THE HILLS SHIRE COUNCIL

15 March 2018

Council received notification on 5 February 2018 of a Section 75W application made to the NSW Department of Planning and Environment to modify a Part 3A approval for a seniors living development at 34-36 Memorial Avenue, Kellyville.

10am Proposed Solar Analysis on Cluster 1

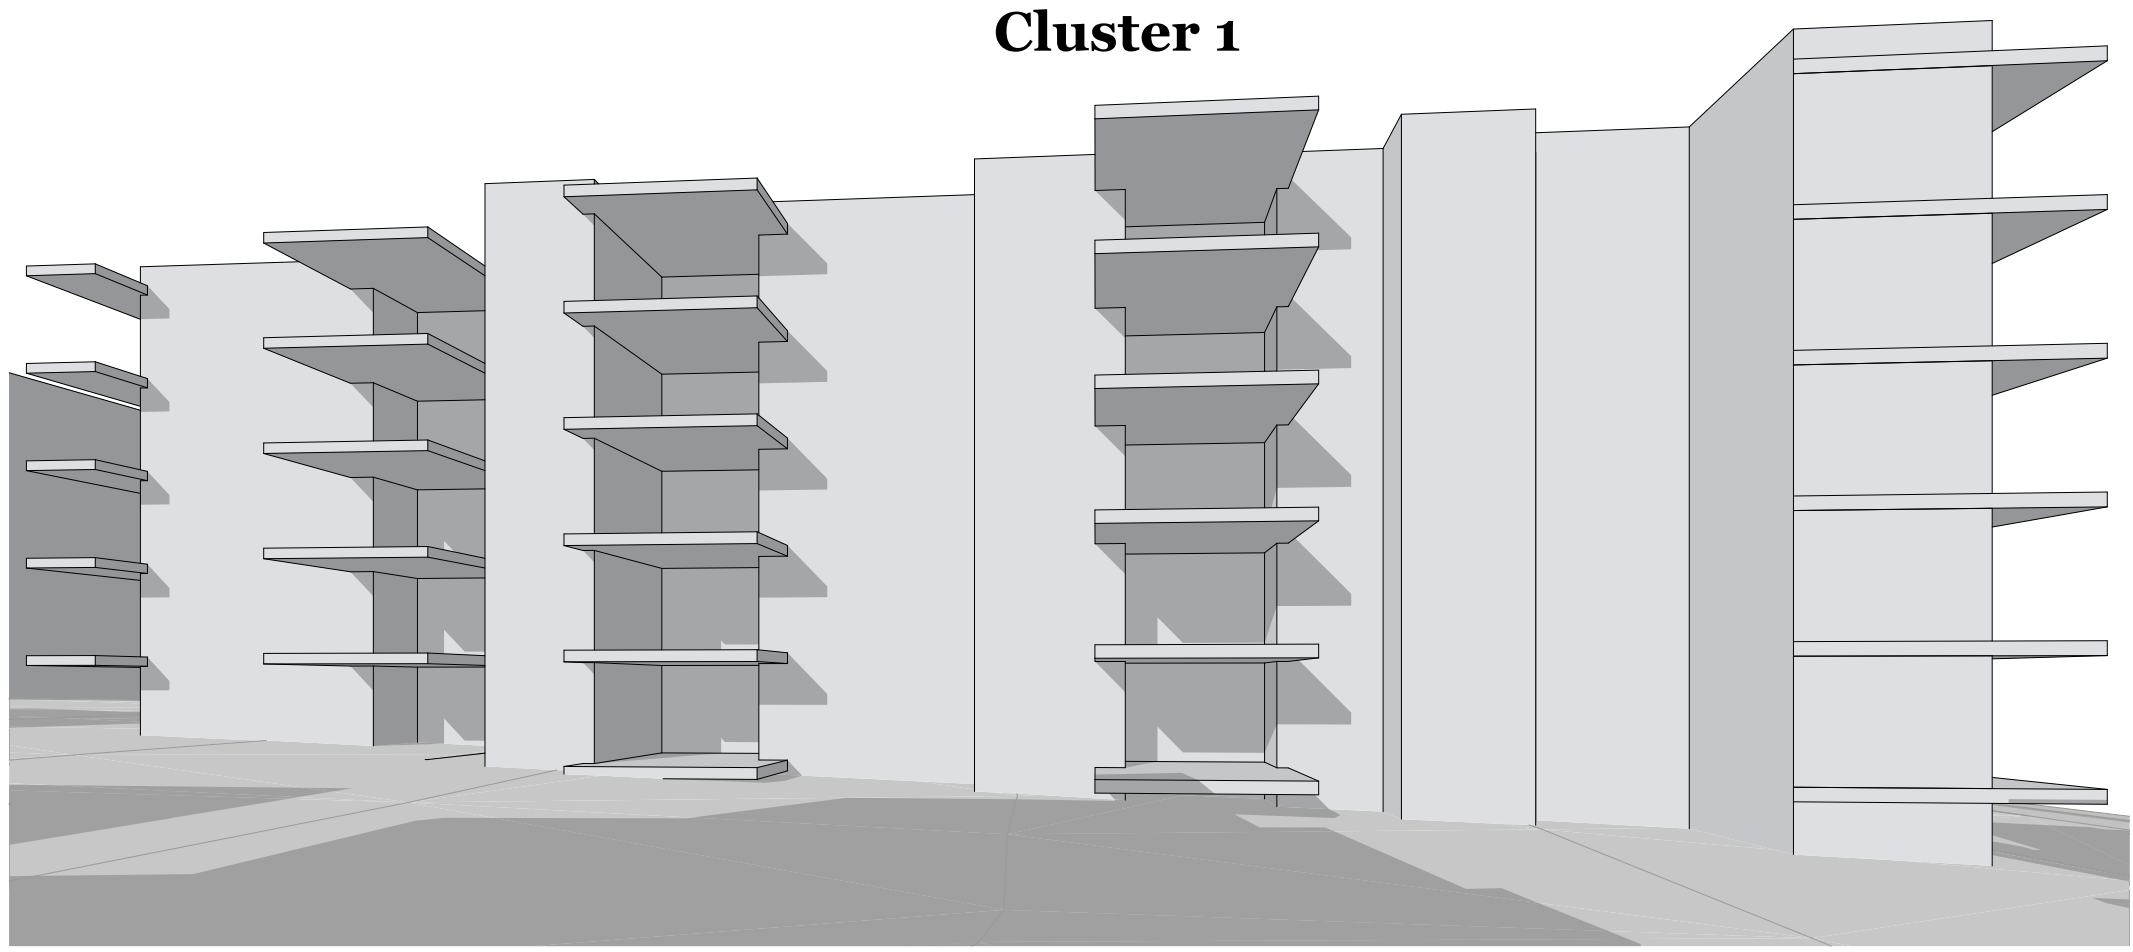
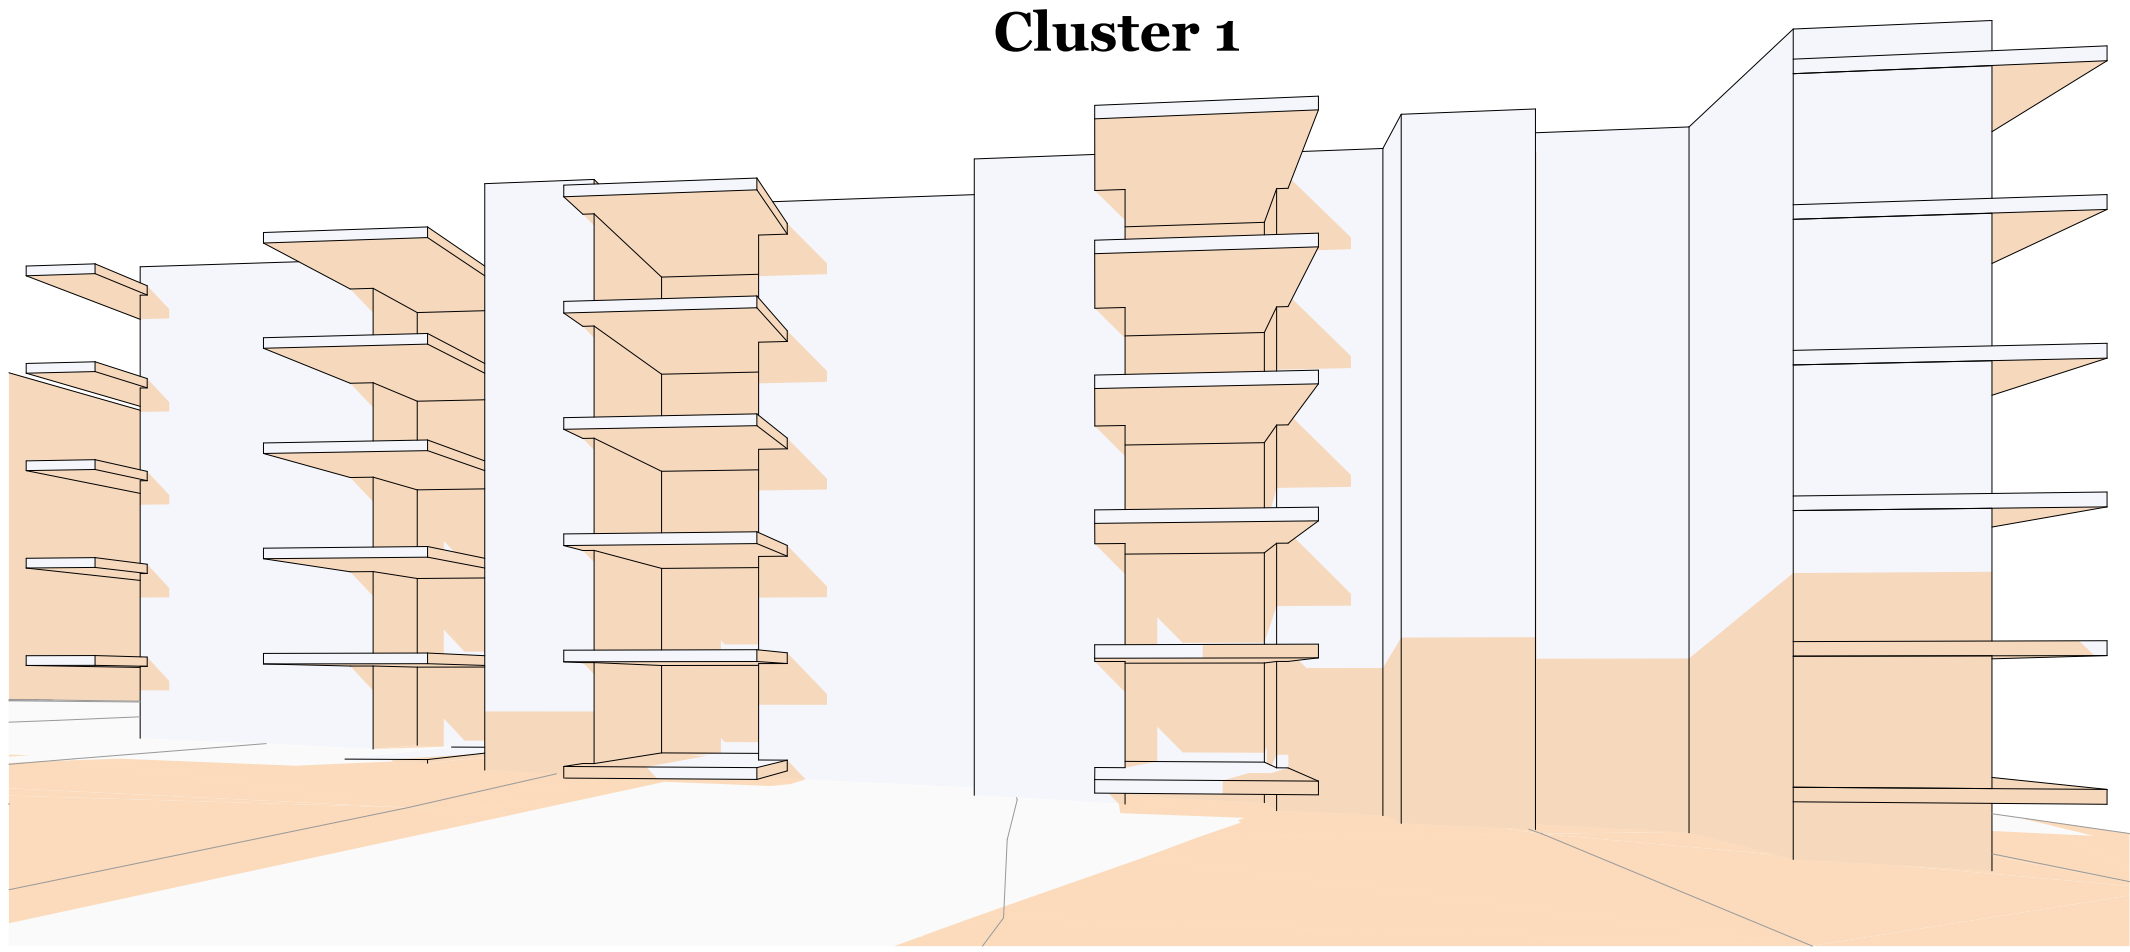
- The proposal has not provided a clear assessment of the proposals impact on the solar access afforded to adjoining buildings known as Cluster 5, or the RACF impact on the solar access afforded to the proposed buildings. Analysis similar to that provided for Cluster 1 should be provided to the northern elevation of Cluster 2, 3 and 4 (to assess the impact of the RACF), and the northern elevation of Cluster 5.
